From:
To: [DCAdmin](#)
Subject: Fwd: 2022/94023 Objection planning officer Laura Yeadon
Date: 08 January 2023 05:41:37

Please find the following objections for the proposed works at Number 6, Siskin Gardens, Netherton, HD4 7FB.

client	MR MIDDLEBROOK		
project	PROPOSED REAR EXTENSION 6 SISKIN GARDENS NETHERTON HUDDERSFIELD, HD4 7FB		
drawing	PROPOSED PLANS		
revision	notes	date	drawn
*	*	*	*
scale :	1:50 AT A1	09.22	PB
project no.	2239	drawing no.	02

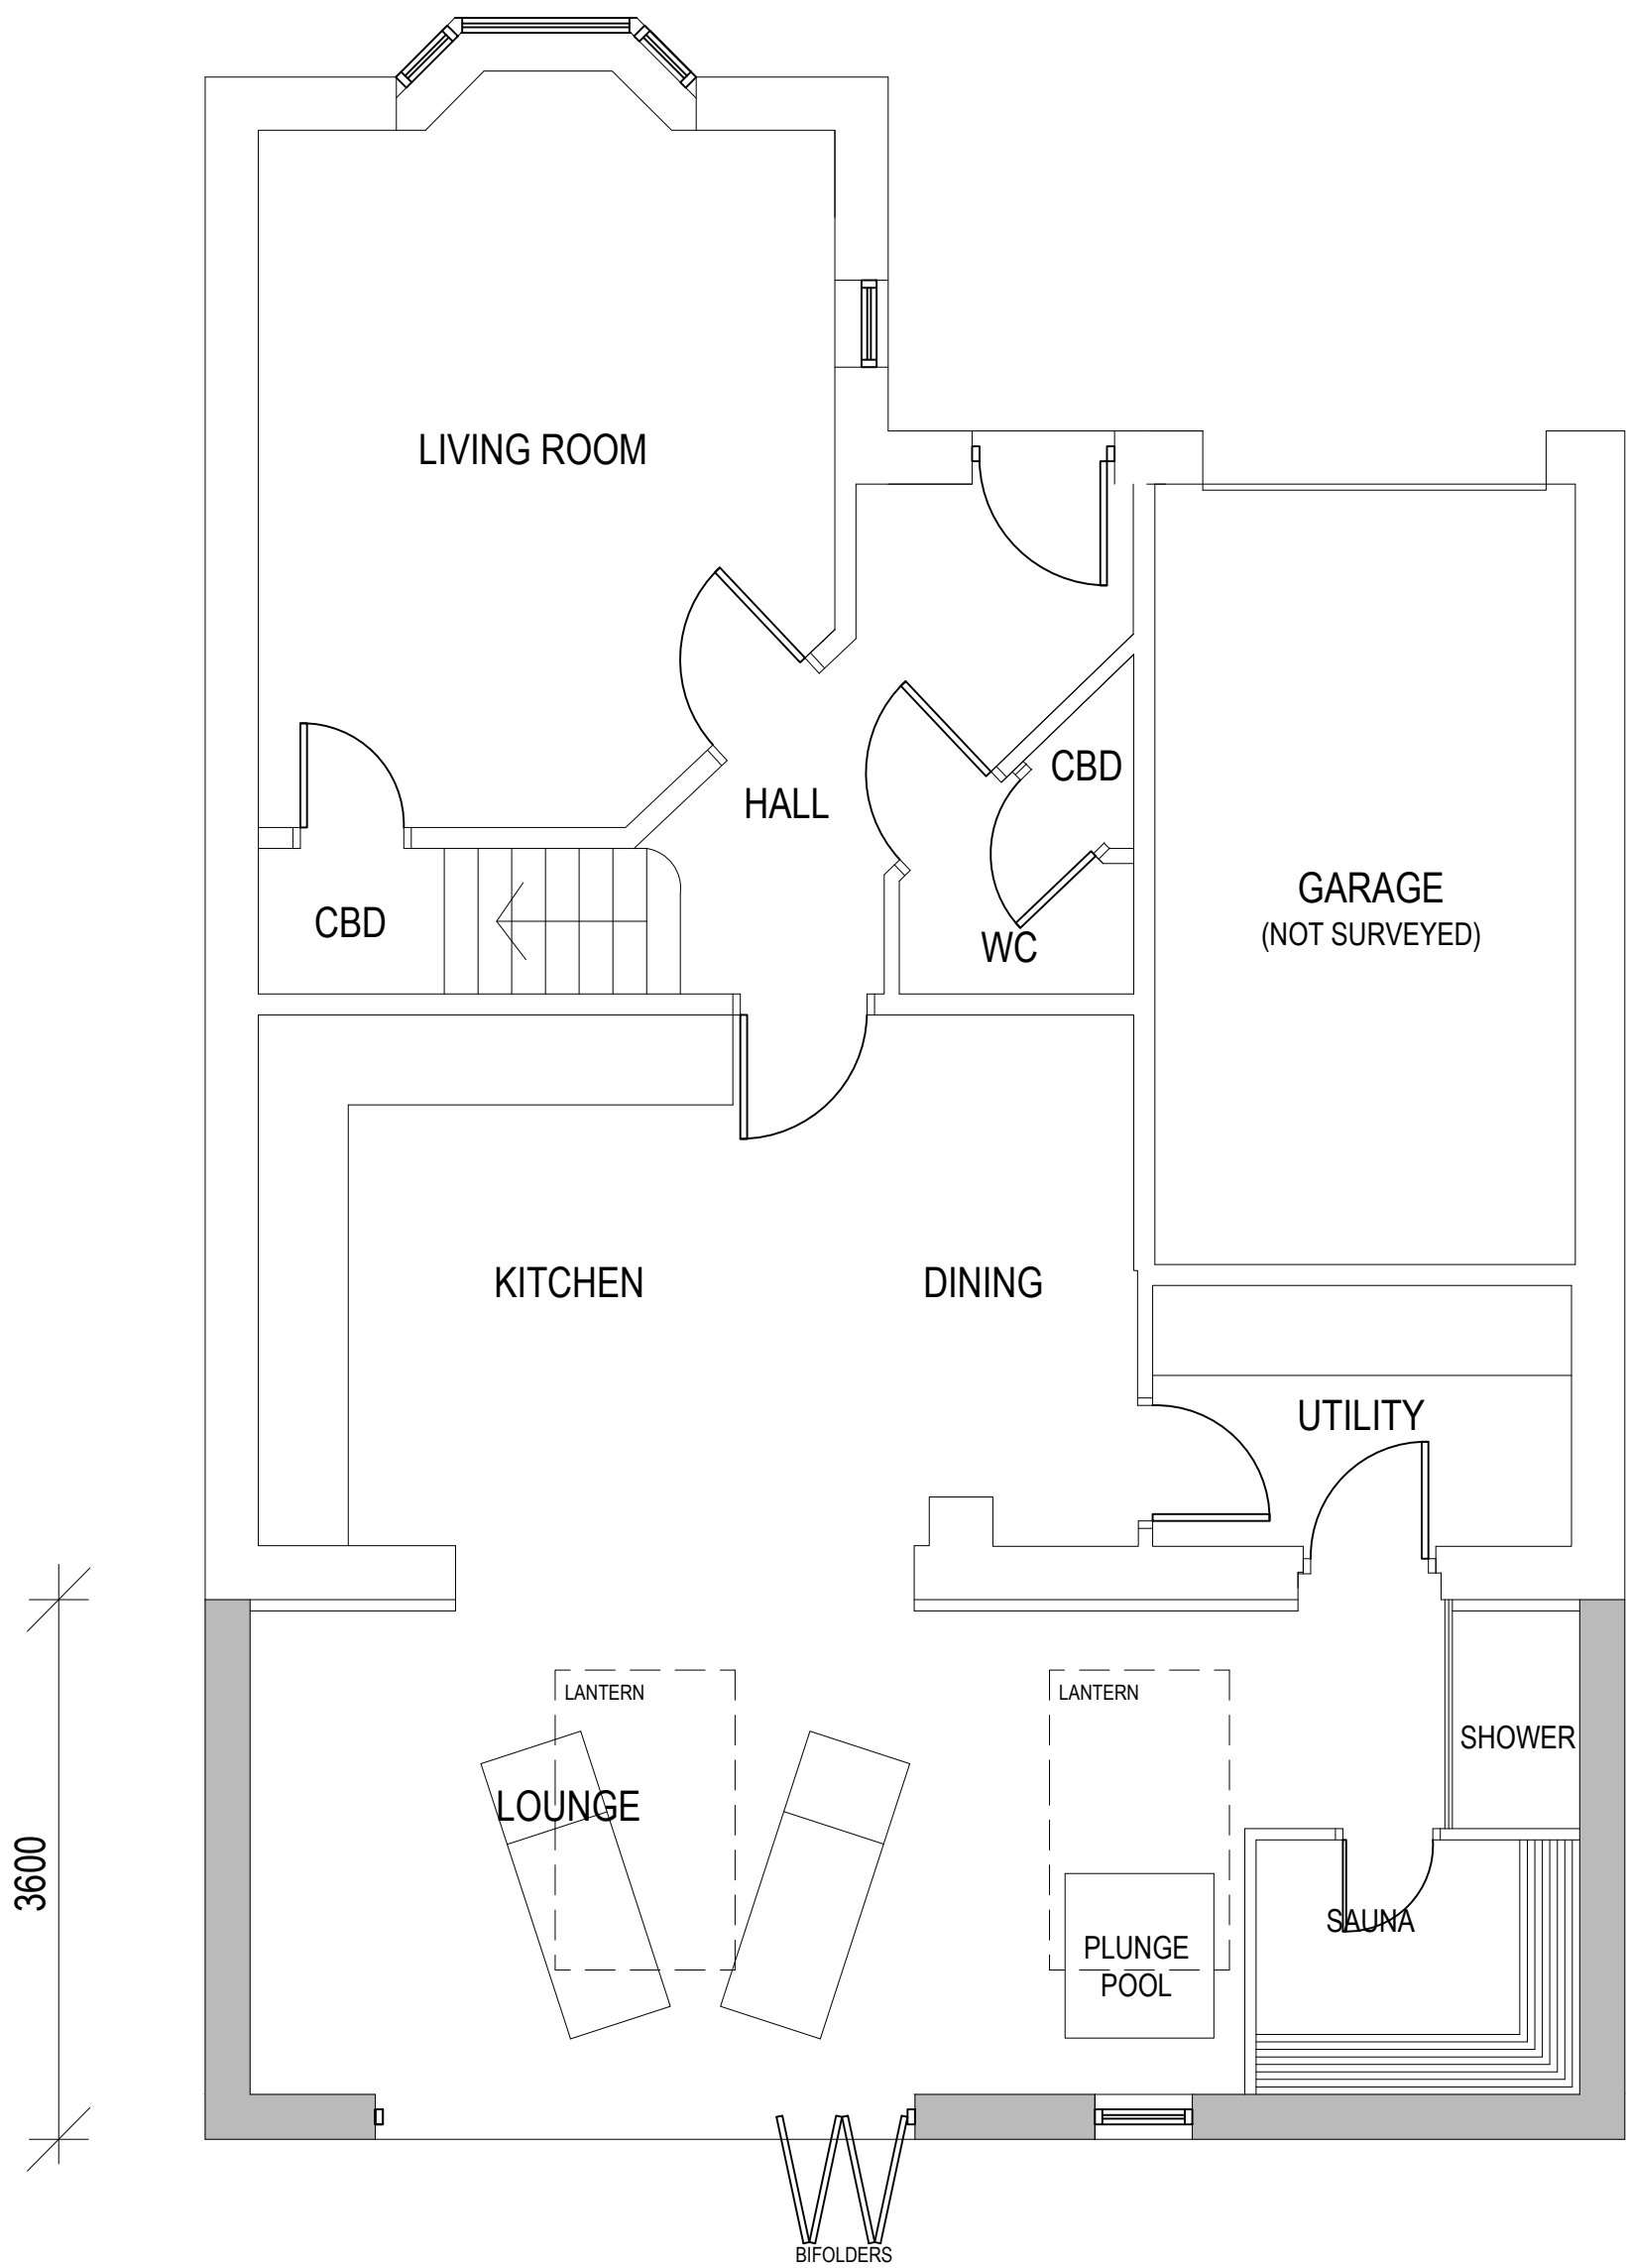
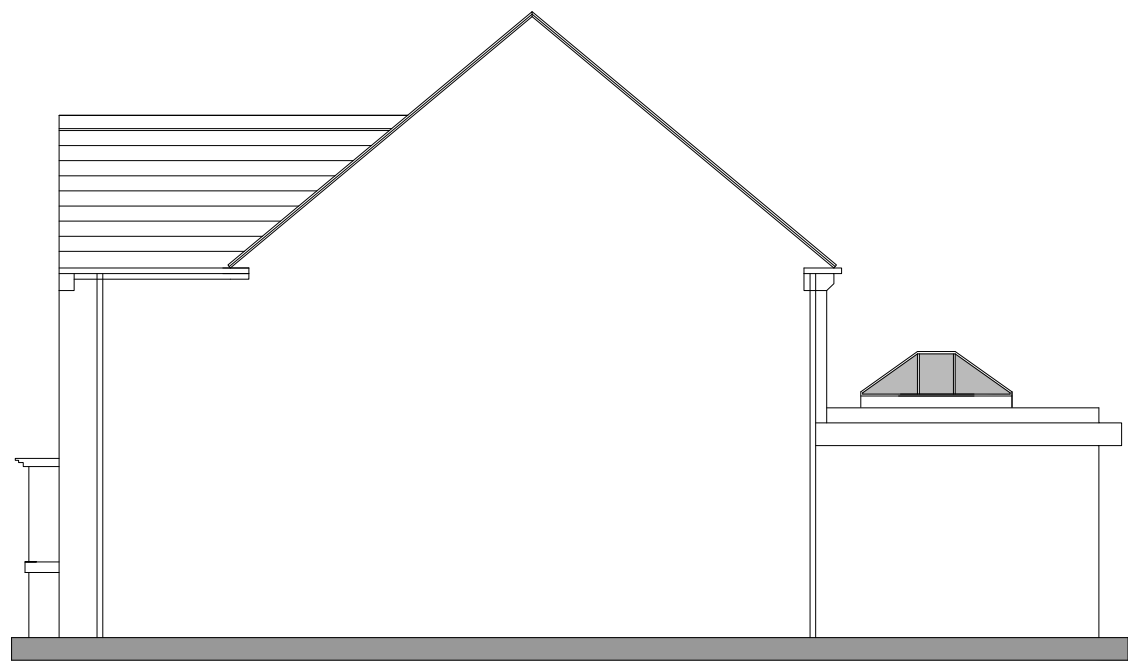
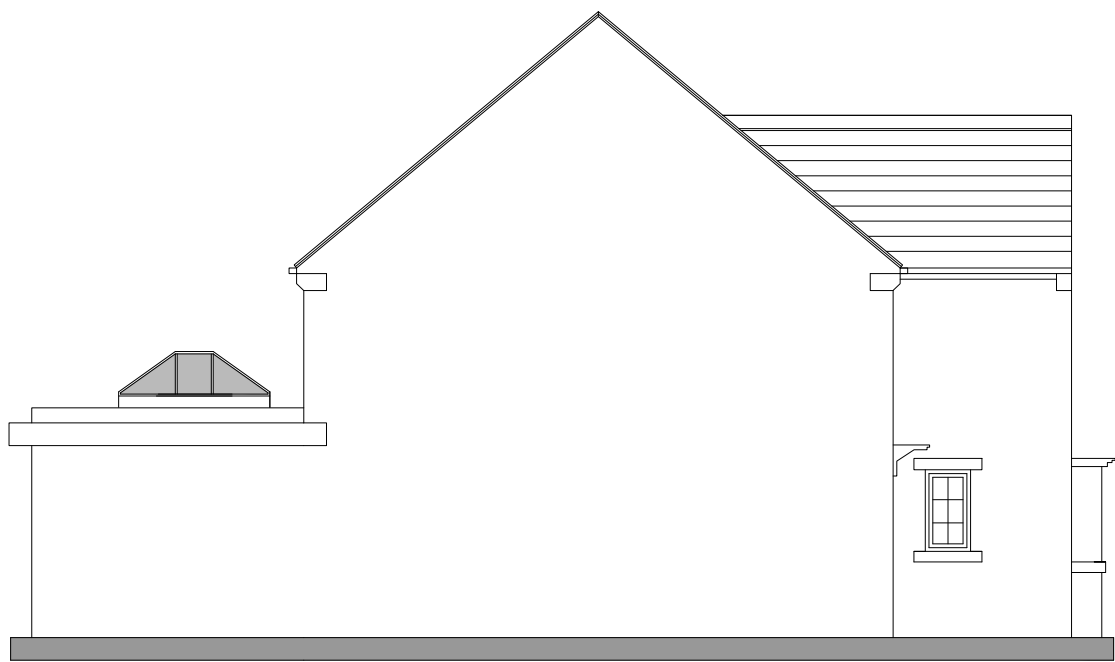
Does Kirklees Council practice the 45 degree rule as this would appear to be in significant breach of that to which we are very concerned.

The extension is going to impact upon our lighting in the main kitchen and dining area which is where we spend the majority of our time as a young family.

There will be a substantial loss of light to the garden in what is already a shaded adjoining boundary. It will be dark and negatively impact on our garden.

The length itself of the proposed extension is overbearing to our property and garden with a huge wall being the vantage point.

The plans itself due to the very long length combined with the sky light windows are out of character with neighbouring properties and the area itself.
